INDEPENDENT EXPERT REVIEW

WHITE ROCK WIND FARM PROPOSAL

*Prepared for
NSW DEPARTMENT OF PLANNING
& ENVIRONMENT*

17th July 2019
REF: 990-Z1-01
REVISION: D

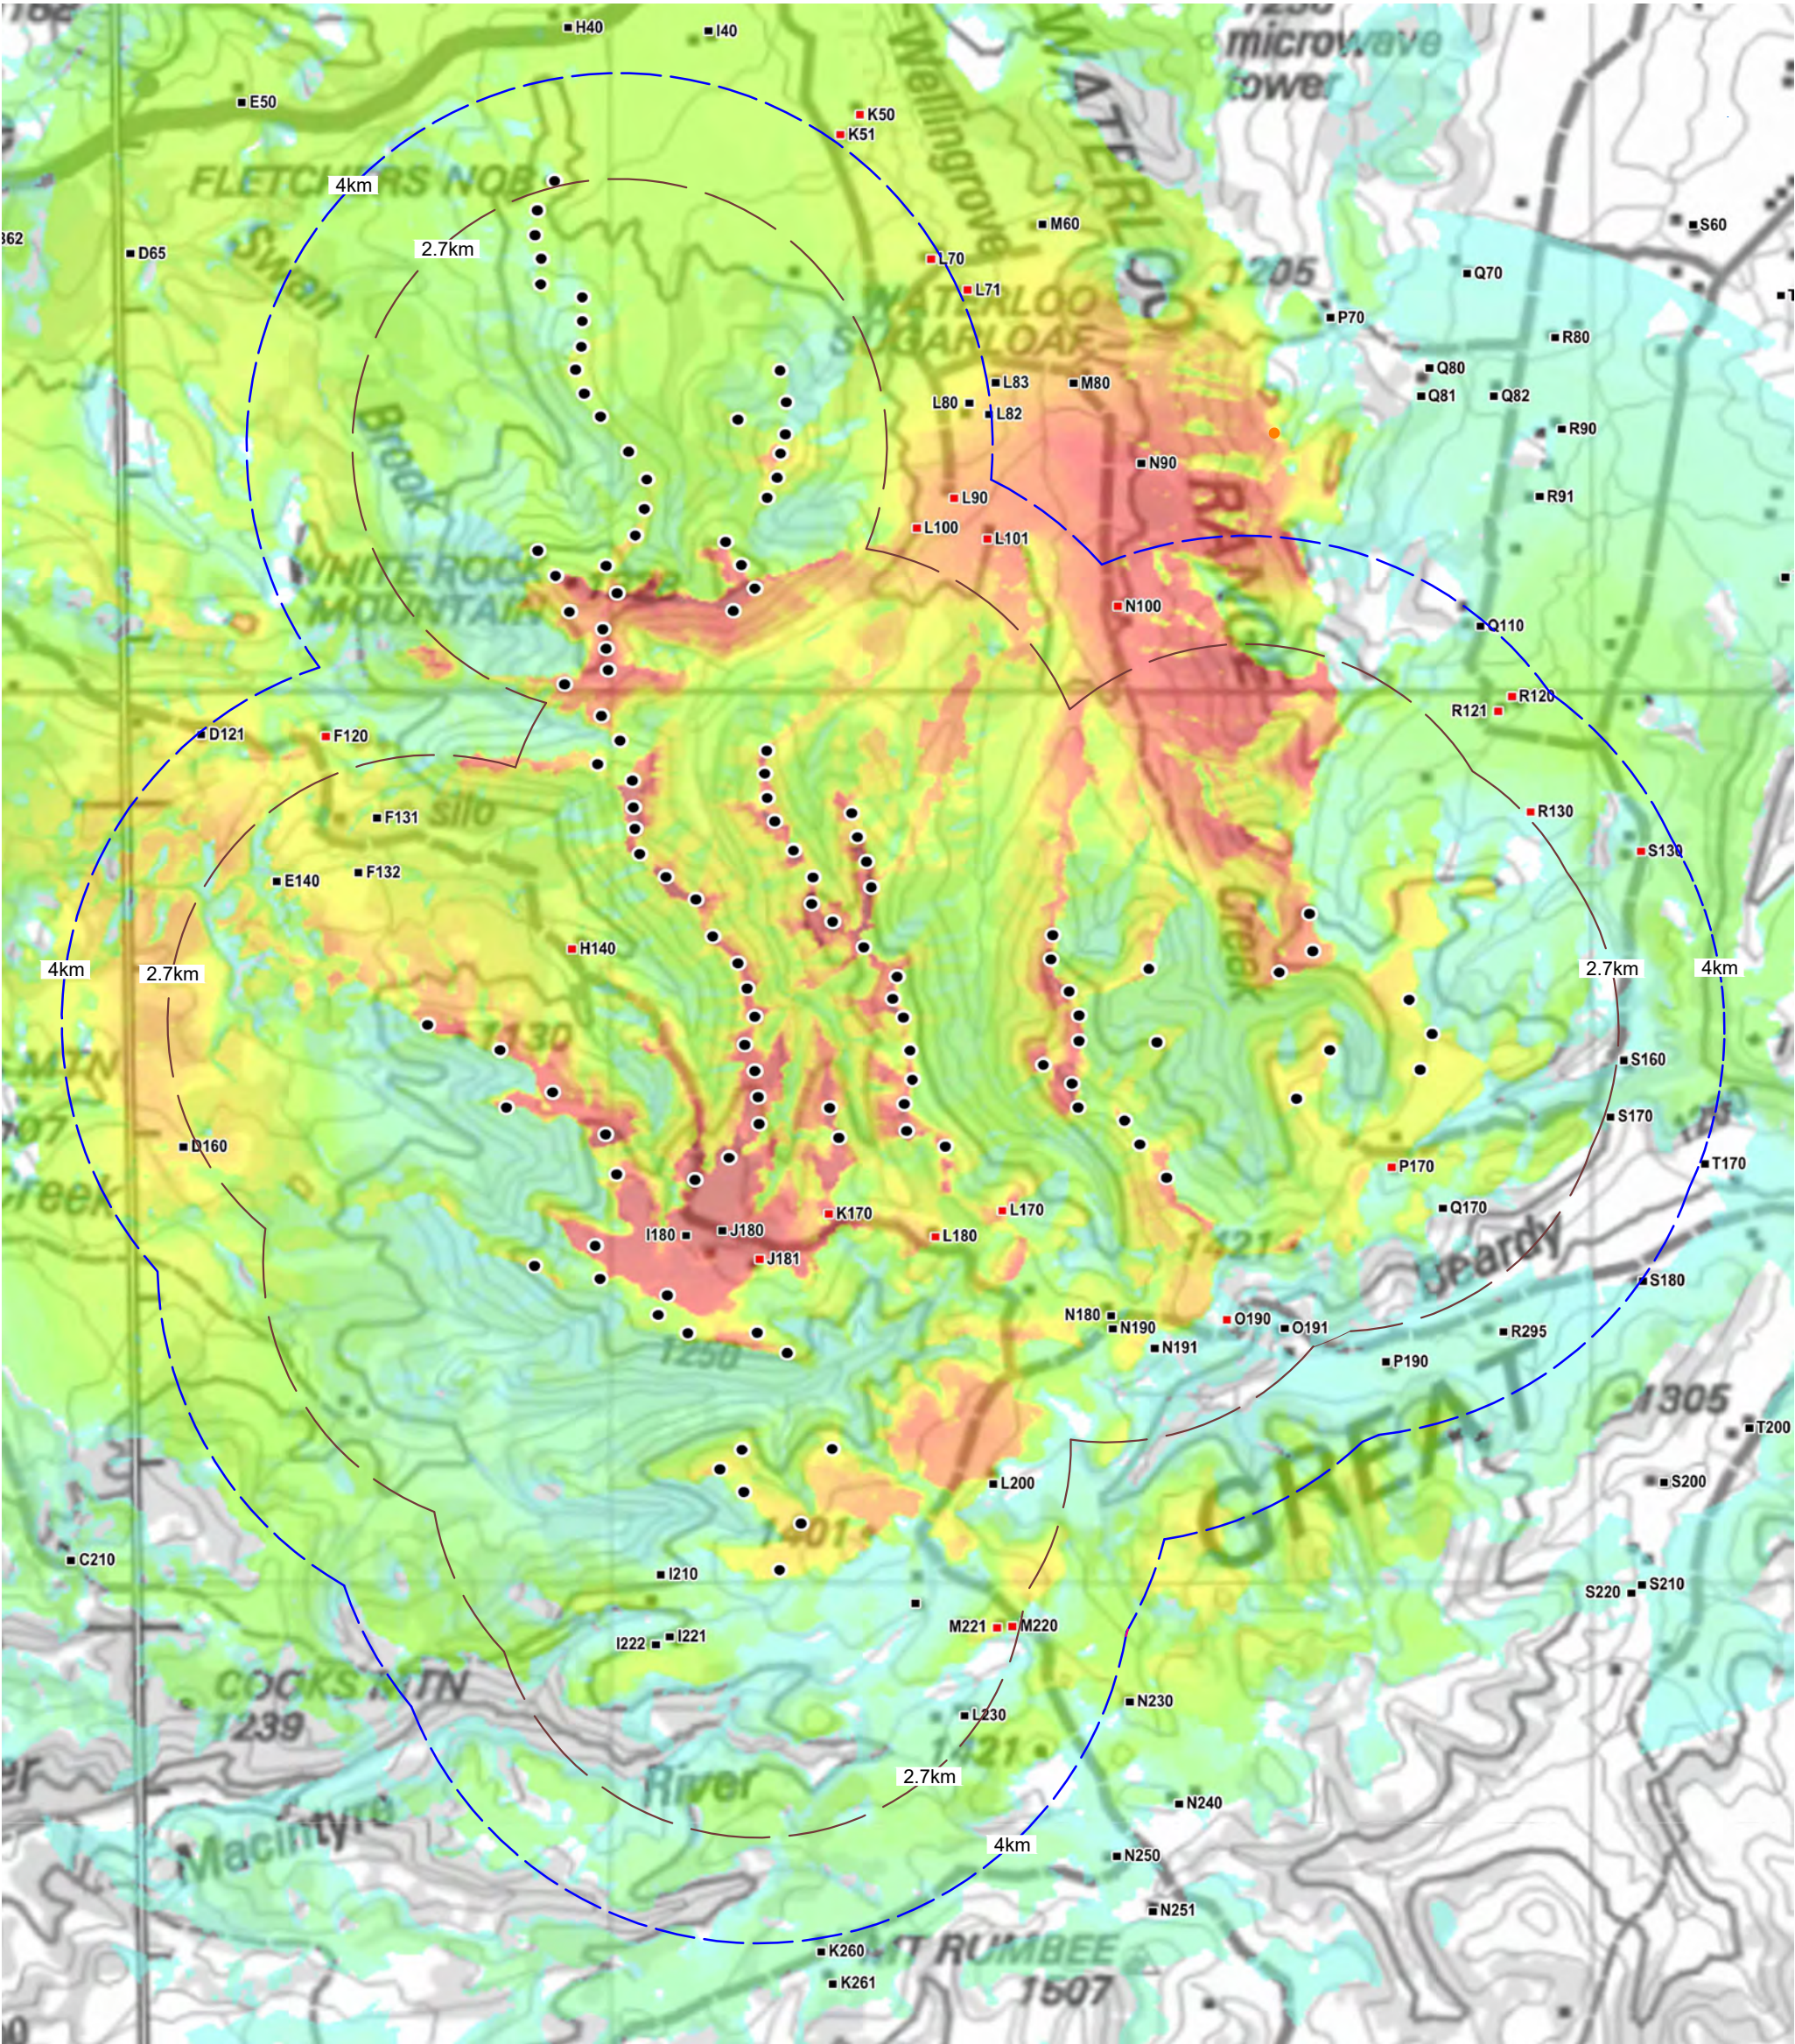
It should be noted that this statement only refers to any "additional significant cumulative visual effects". This is not a measure of the complete cumulative impact of the project and any surrounding projects. This statement also makes no allowance for any rating of cumulative impacts for individual residences. As the previous the 2012 Approval LVIA also makes no attempt to quantify cumulative impacts, there seems to be no data to act as a baseline from which this statement can be validated.

The VAB clearly indicates and describes the correct use of the multiple wind farm tool as a key step in assessing the overall visual impacts of a wind farm and the omission of this step in the LVIA results in no preparation of sector analysis or angle of view analysis that would provide an analytical basis upon which to base a conclusion.
